**CITY OF PORTLAND, MAINE
DEVELOPMENT REVIEW APPLICATION
PLANNING DEPARTMENT PROCESSING FORM
DRC Copy**

2003-0184

modular single family
Project Name/Description

Subject: 30 Central Avenue Extension
(ID # 2003-0184) (CBL# 088K035)

REVISION: 10-16-03~ADDED EROSION CONTROL AND NOTES.  
**SITE PLAN**  
 FOR A PROPOSED SINGLE FAMILY HOME  
 30 CENTRAL AVENUE EXT. PEAKS ISLAND, MAINE  
 FOR: RICHARD D. GRANT

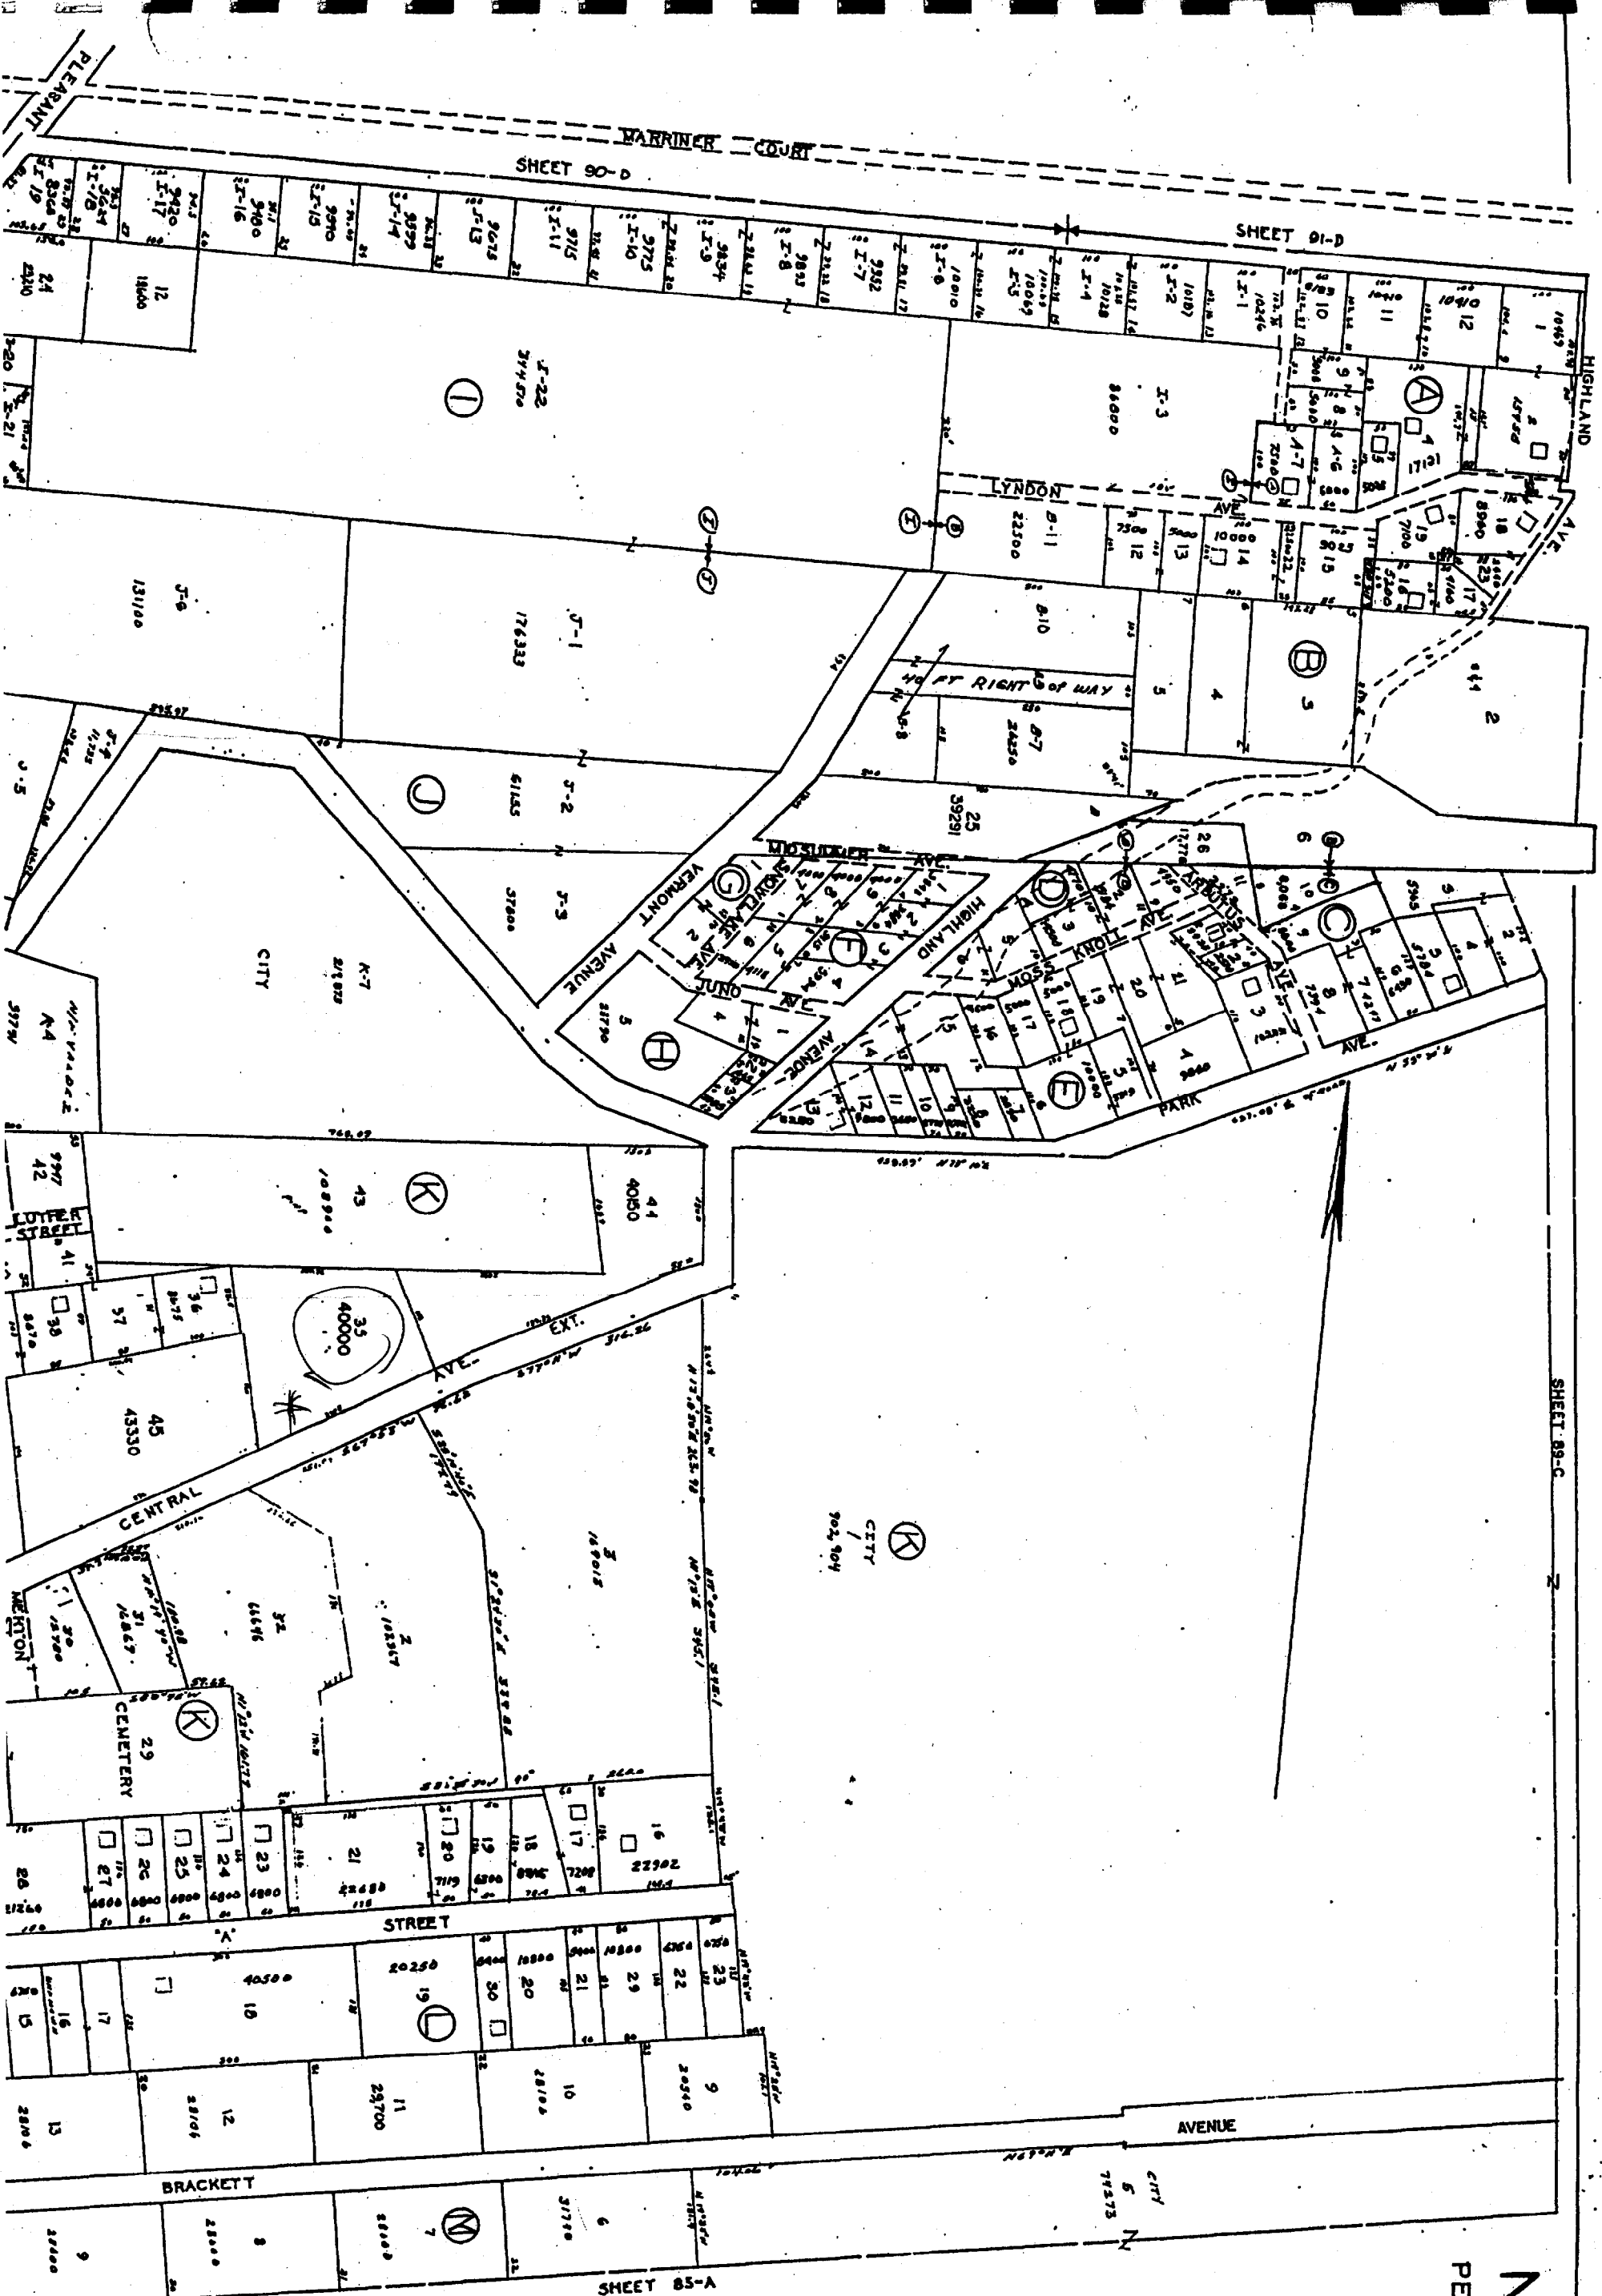
1. Is this lot within the Shoreland zone? If so, please show the 250' setback line and limits of clearing.
2. There appears to be no grading changes to the east side of the proposed structure. Does the building have a daylight basement or will it have approximately 7 feet of wall showing?
3. Please add erosion control measures to the site plan.

REVISION:
SITE PLAN
 FOR A PROPOSED SINGLE FAMILY HOME
 30 CENTRAL AVENUE EXT. PEAKS ISLAND, MAINE
 FOR: **RICHARD D. GRANT**

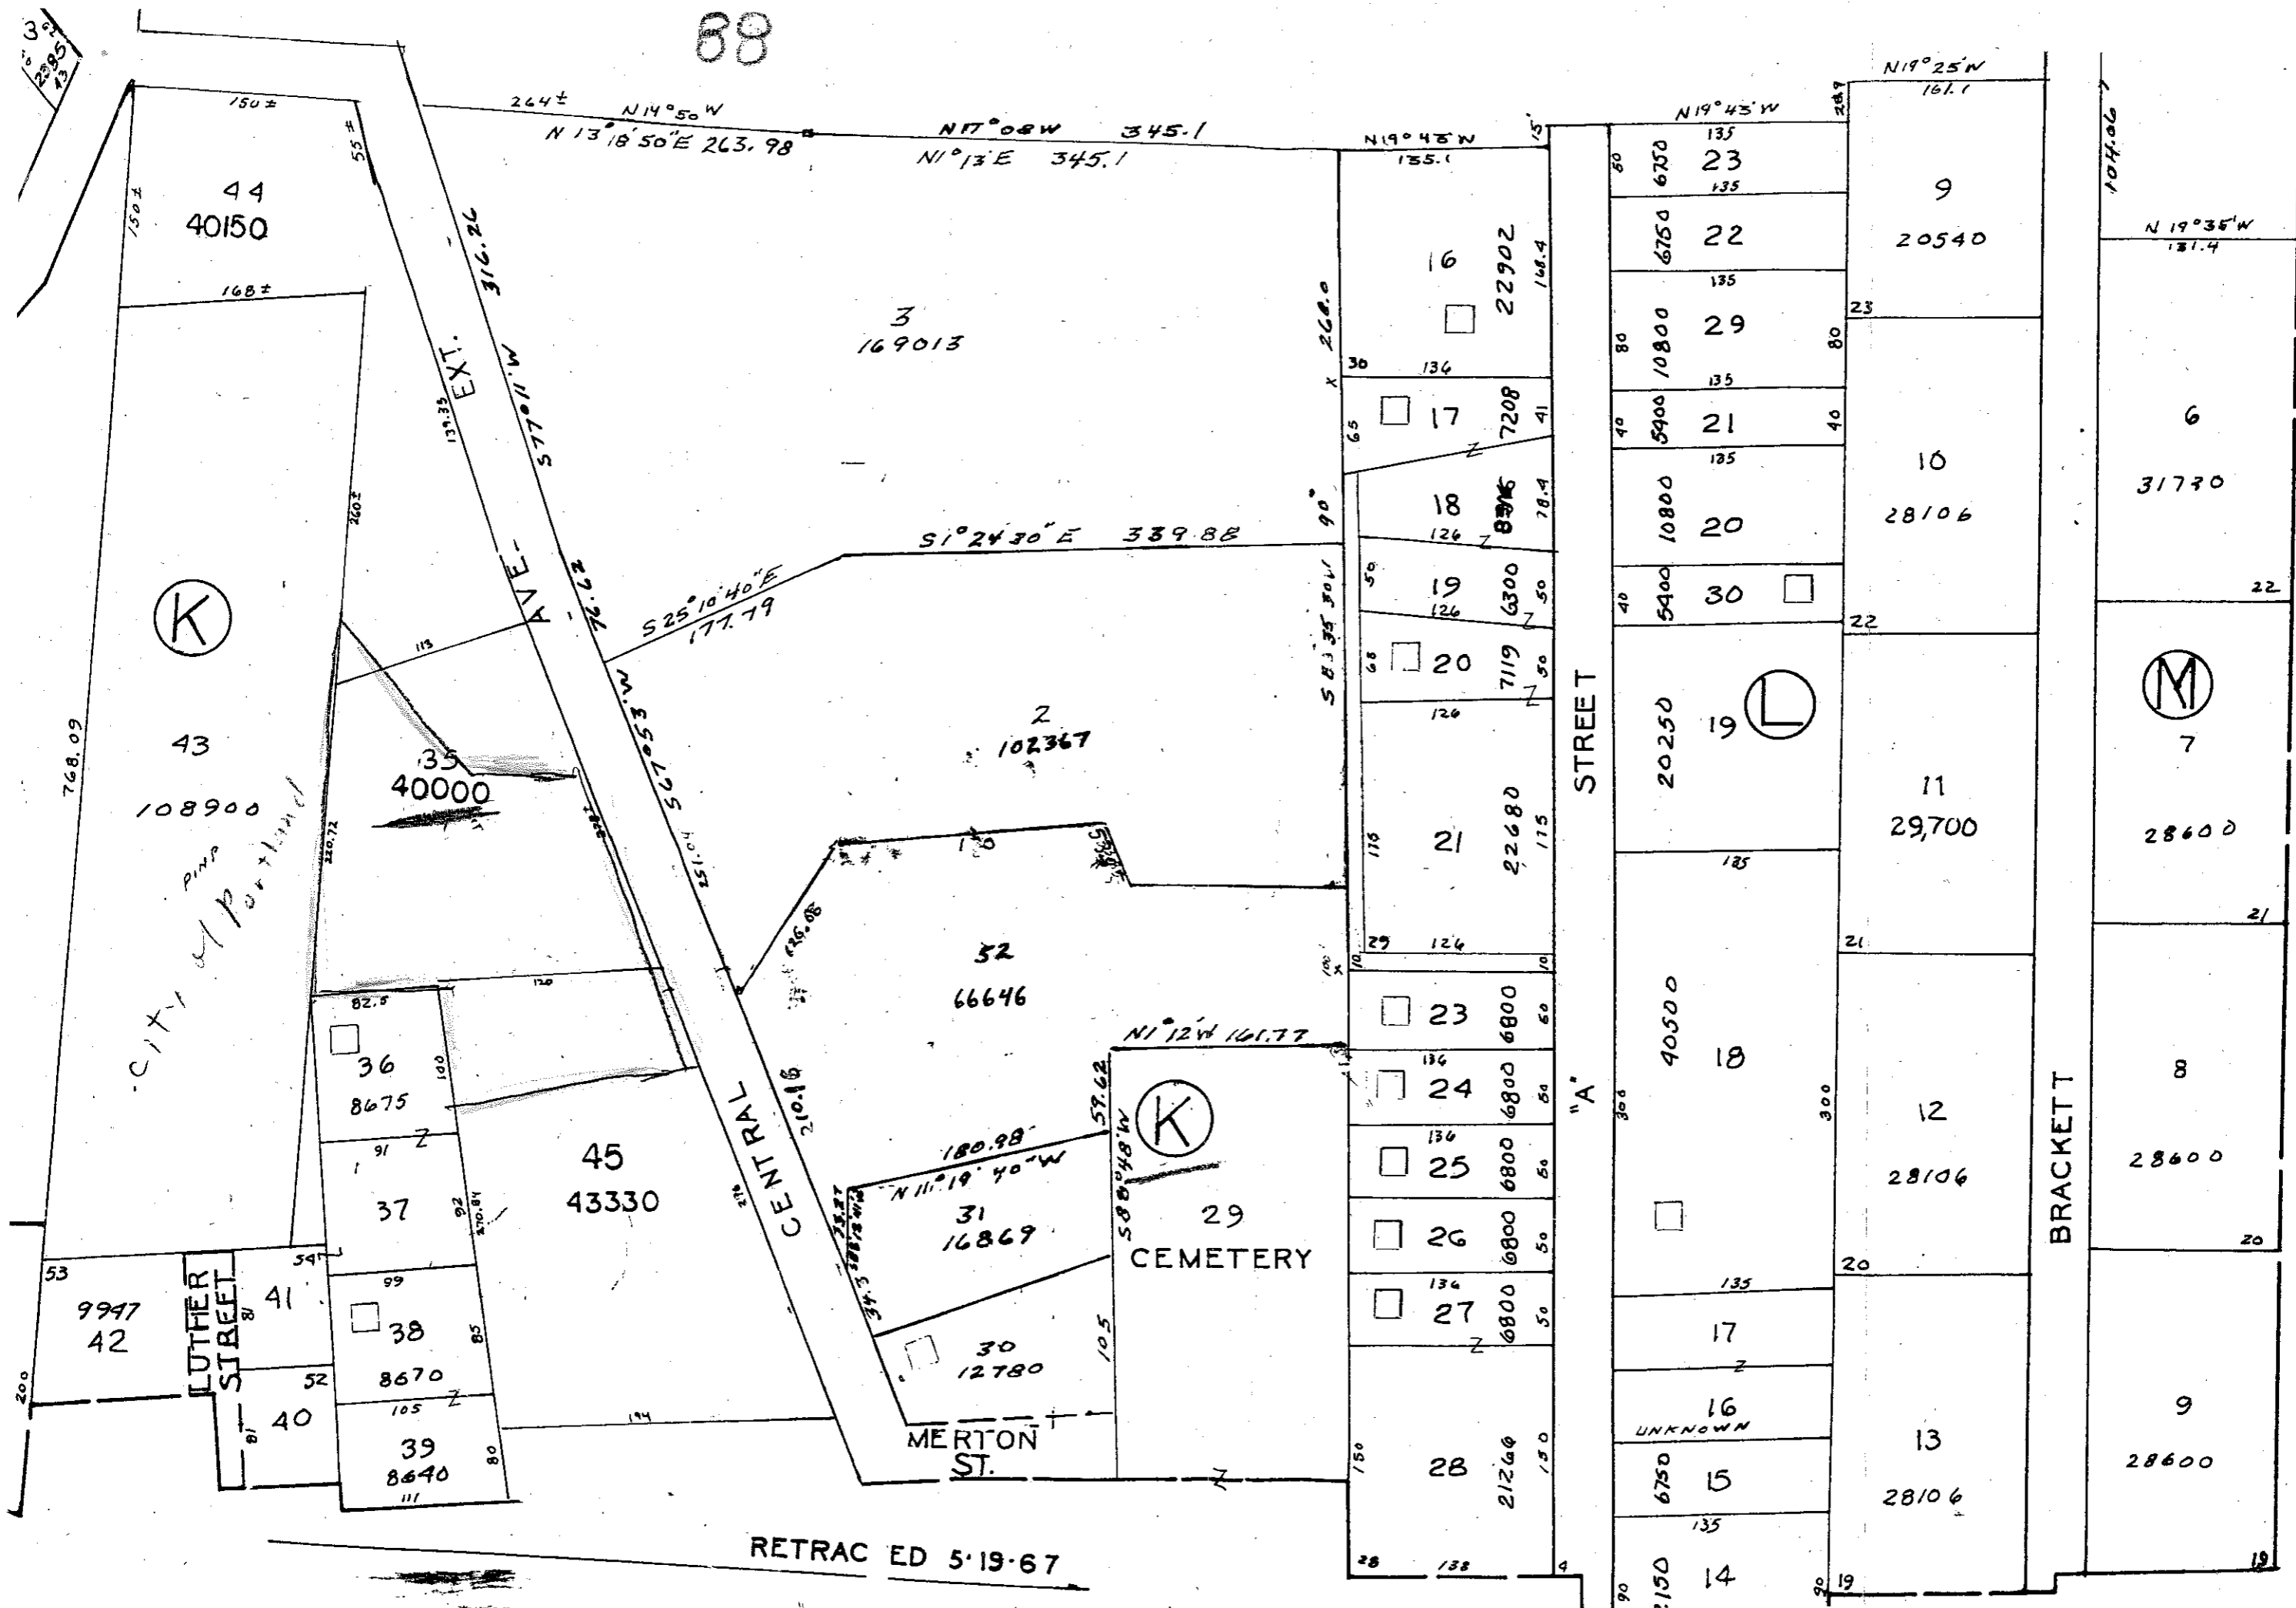
Thank you for your application for a single family at 30 Central Avenue extension. Upon review of the plan, it appears that this design would constitute a subdivision. Also, the deed submitted and lot lines shown do not match the City's Assessors maps.
